Please ask for: Sian Eggington
Email: sian.eggington@terraquest.co.uk
Telephone: 0121 234 1390
Our Ref: WA/122/21/HH
Your Ref:
Date: 20th December 2021

Application for Planning Permission for Works or Extension to a Dwelling

Development: Construction of rear extension.
Location: Belvedere London Road Fontwell Walberton BN18 0SG

PROPOSED SITE PLAN
scale 1:200

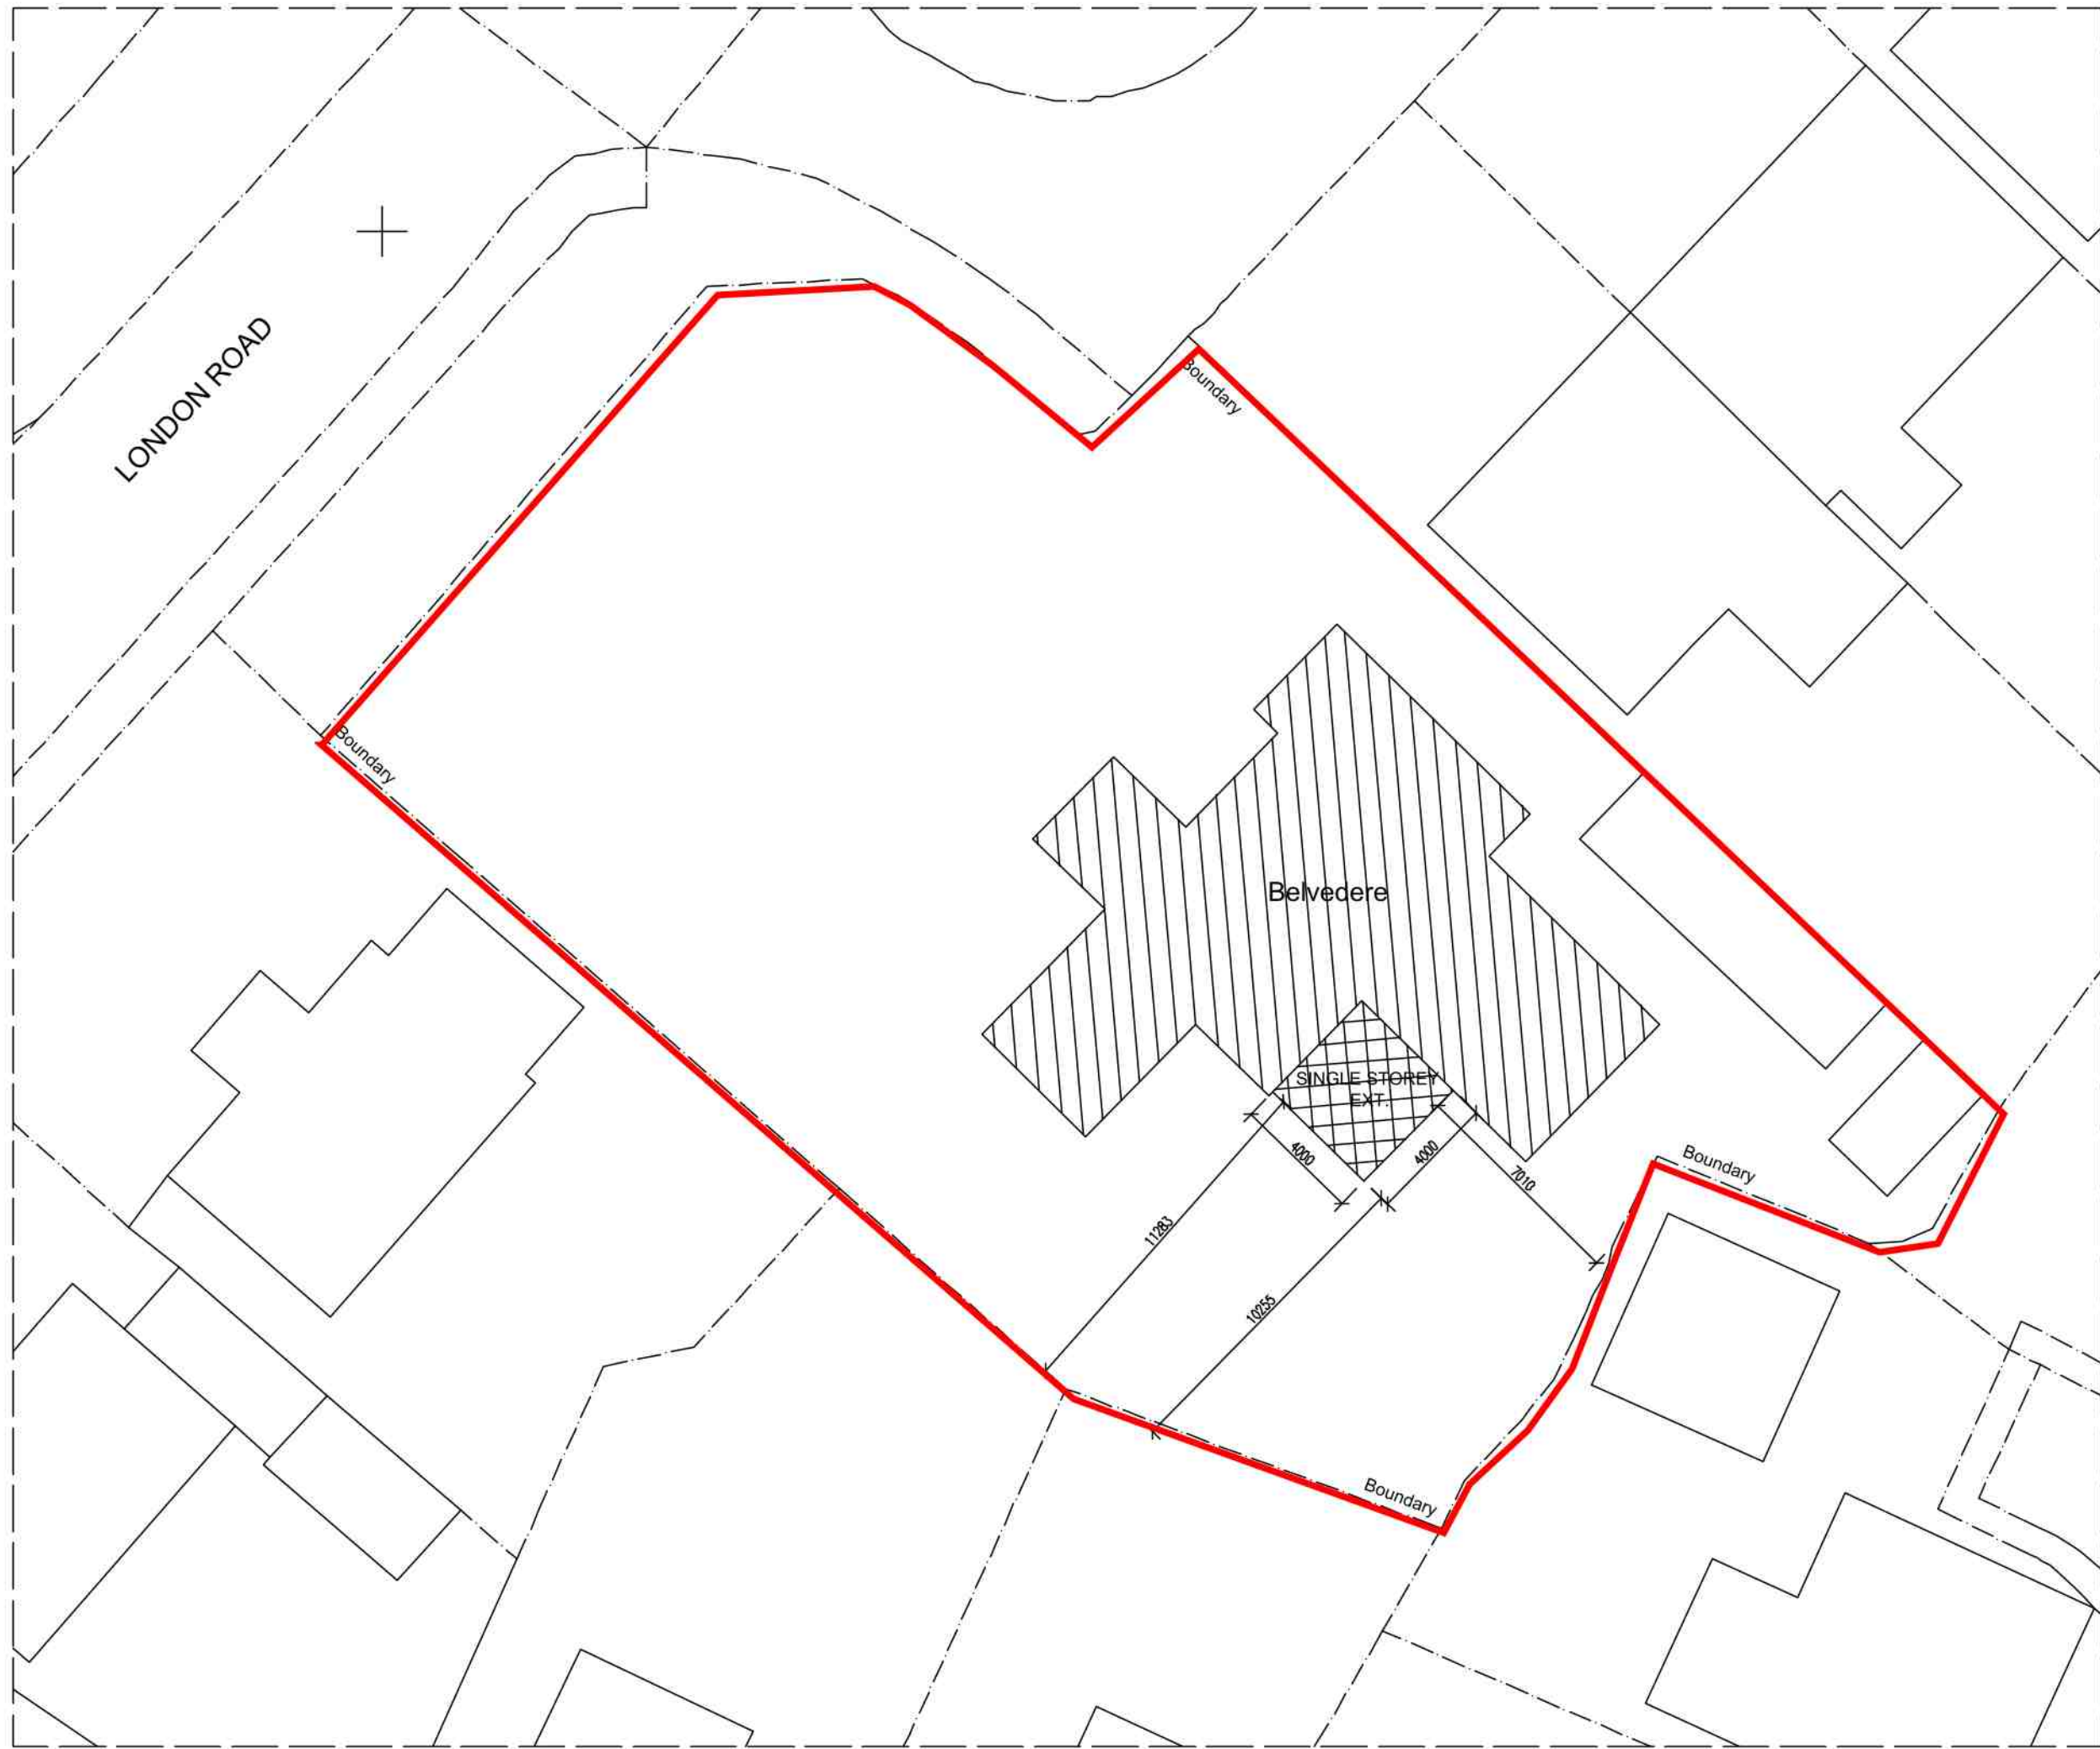
Block Plan: You are required to include dimensions from the proposed extension(s) to all site boundaries. Please amend
